**Consultation Response from KC,
Trees**
2023/93023 Woodlands, 4, Highbridge Lane, Skelmanthorpe, Huddersfield, HD8 9JY
Demolition of existing conservatory and erection of replacement orangery
Date Responded: 23/11/2023
Responding Officer: D. Atkinson
Responding Ref: 06/18/t6

Date:	Scale @ A1:	Drawn by:
SEPT 23	1:100	AB
Project No:	Drawing No:	Revision:
243	(0-) 04	A

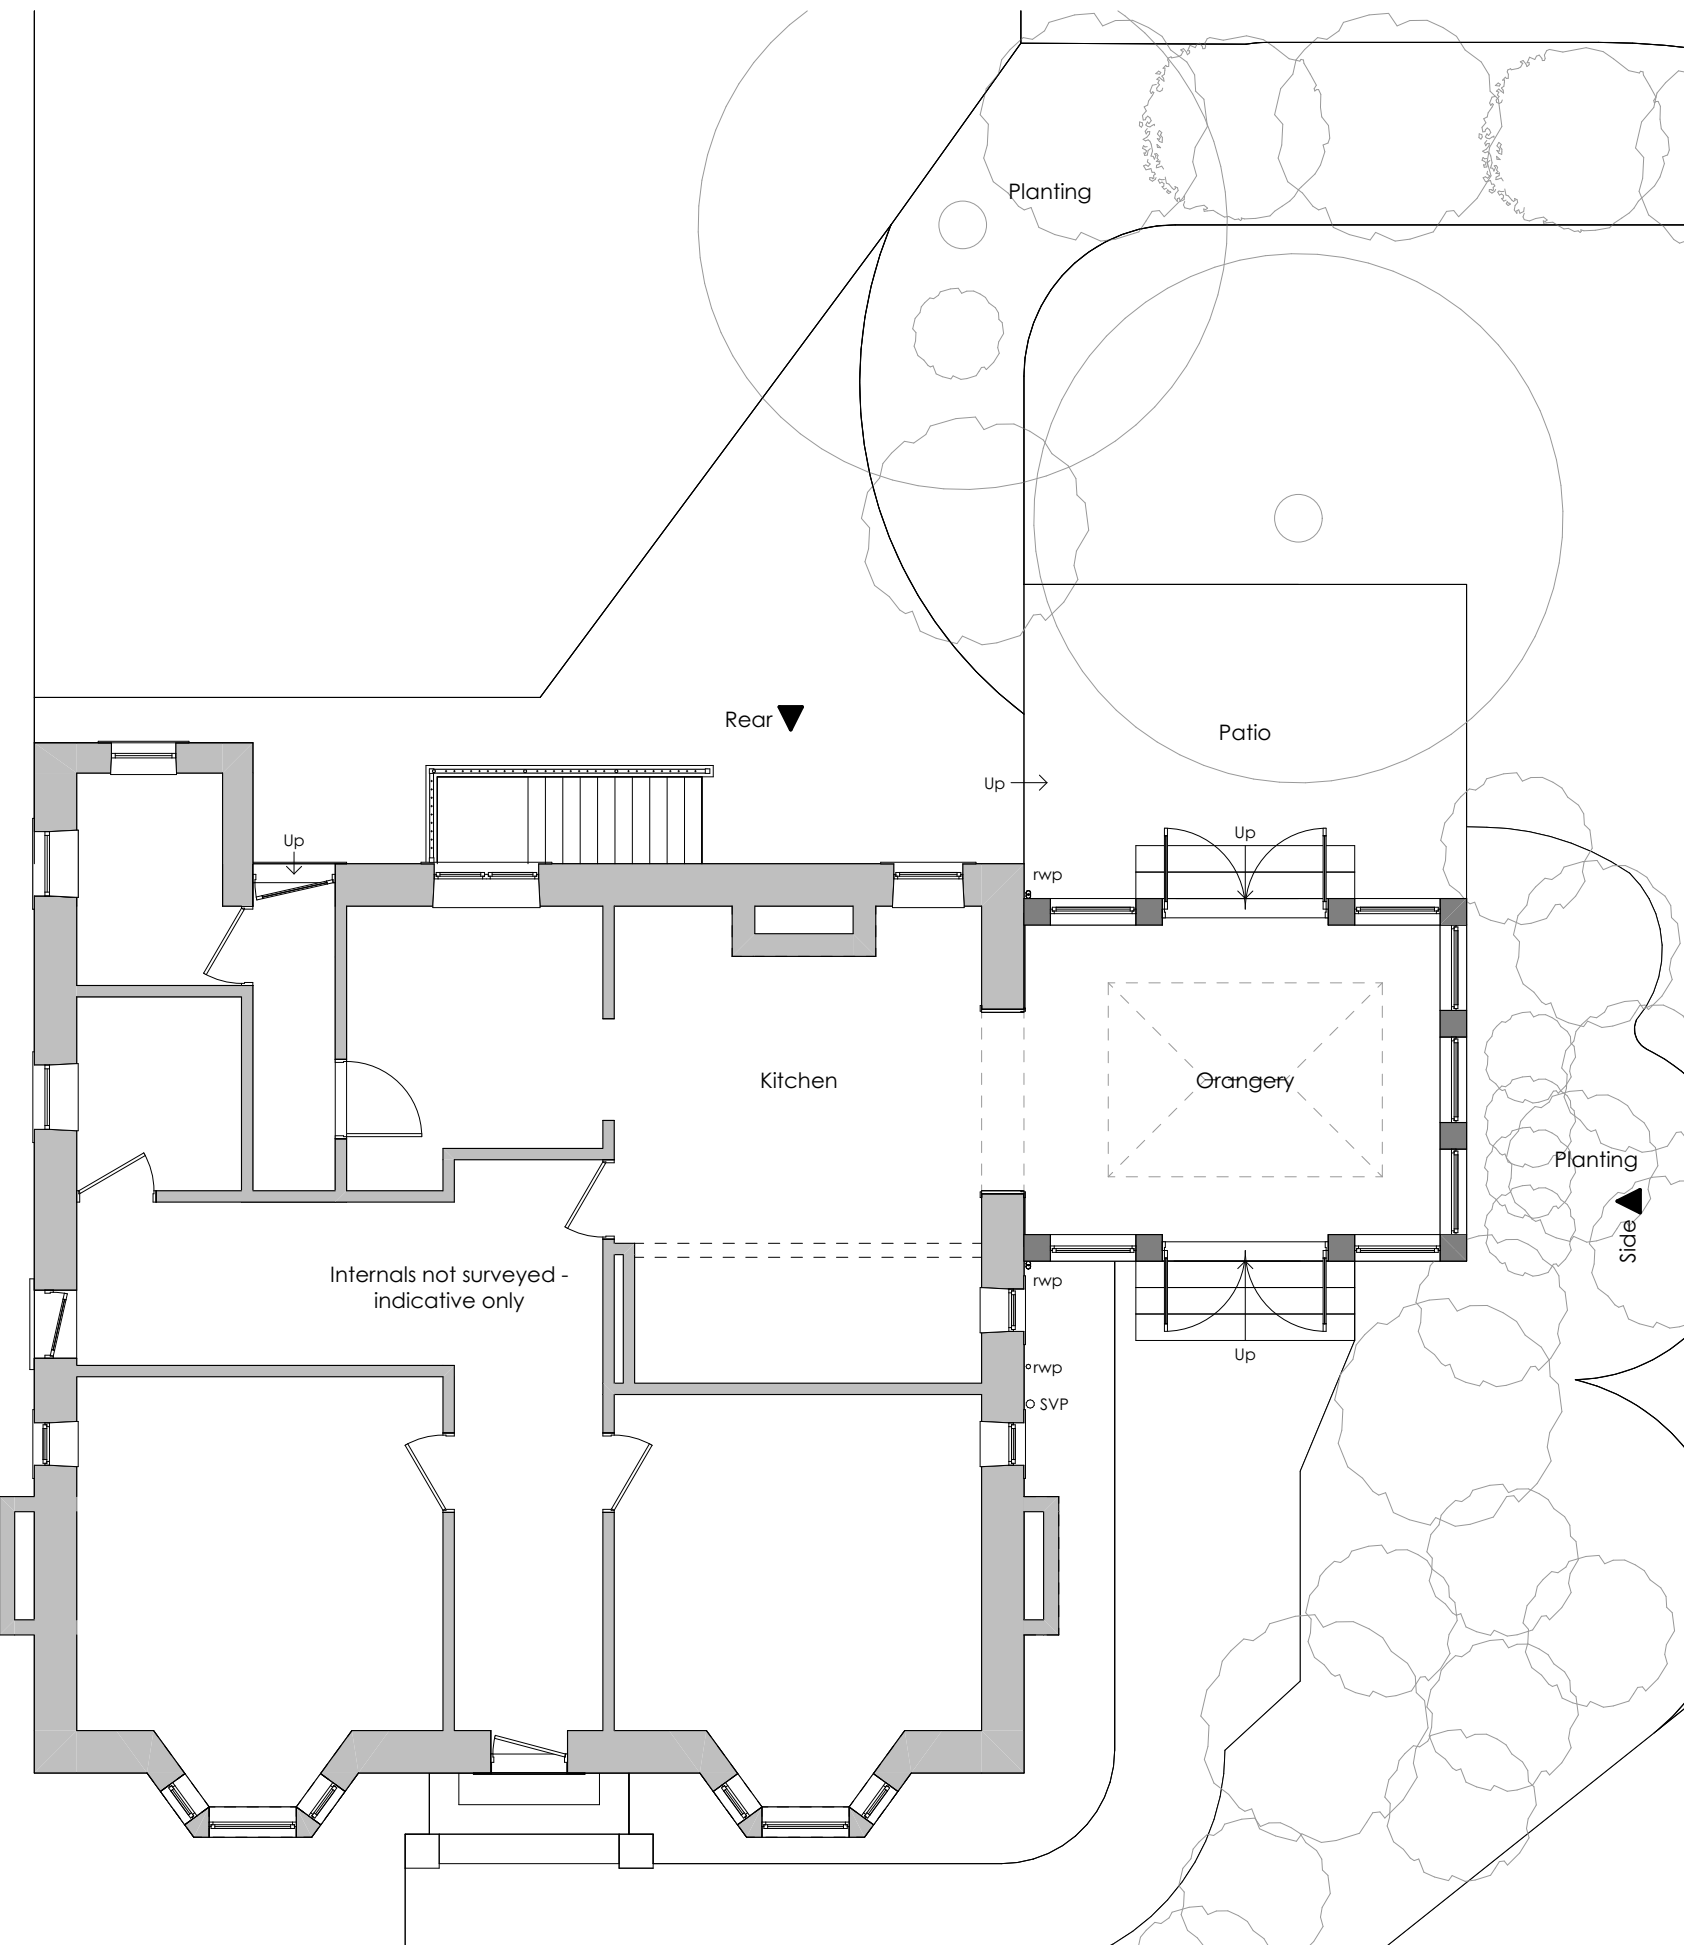
From a trees perspective the proposed replacement orangery is on the same/effectively same footprint of the conservatory and as a result isn't really a concern. There would just need to be some sensible precautions while undertaking the demolition and construction of the proposed.

From the proposed plan (0-) 04 Rev A there is also a proposed extension to the patio area. Although there is no objection in principle to this, because it will be well within the RPA of the adjacent tree how the existing patio is demolished, and new patio area is installed is very important.

The new patio surface must be established above the existing levels of the RPA. The ground must not be skimmed to establish the new hard surface at the former ground level.

A geo-textile membrane laid out in position (to allow drainage and separation and prevent pollution of roots.

A Cellular Confinement System (CCS) will be pinned out in position, using road pins and taking care to avoid any roots. The CCS will be backfilled with clean aggregate (no-fines stone to allow water percolation and gaseous exchange). The first layer of CCS must be infilled by hand, to prevent any machinery from tracking over any unprotected root protection areas. The subsequent layers of CCS must be infilled with machinery only running on filled CCS and not the exposed surface of the RPA, by starting work from outside the RPA, working inwards.

The wearing course of the patio area also needs to be permeable.

The extension of the patio may change the relationship with the tree, by for example increasing the risk (perceived or otherwise) of tree failures to people using the patio and seasonal nuisances like leaf drop and honeydew.

Overall, there is no objection to the proposal from a trees perspective. Subject to conditions requiring:

- A detailed Arboriculture Method Statement (AMS) and Tree Protection Plan (TPP) following the guidance in BS5837:2012 is agreed that details the working methods on site to protect the trees during the demolition of the existing structures/patio and construction of the new structures/patio within the RPA and in the vicinity of the retained trees.
- The patio is constructed using a Cellular Confinement System (CCS) like Cellweb or similar approved.
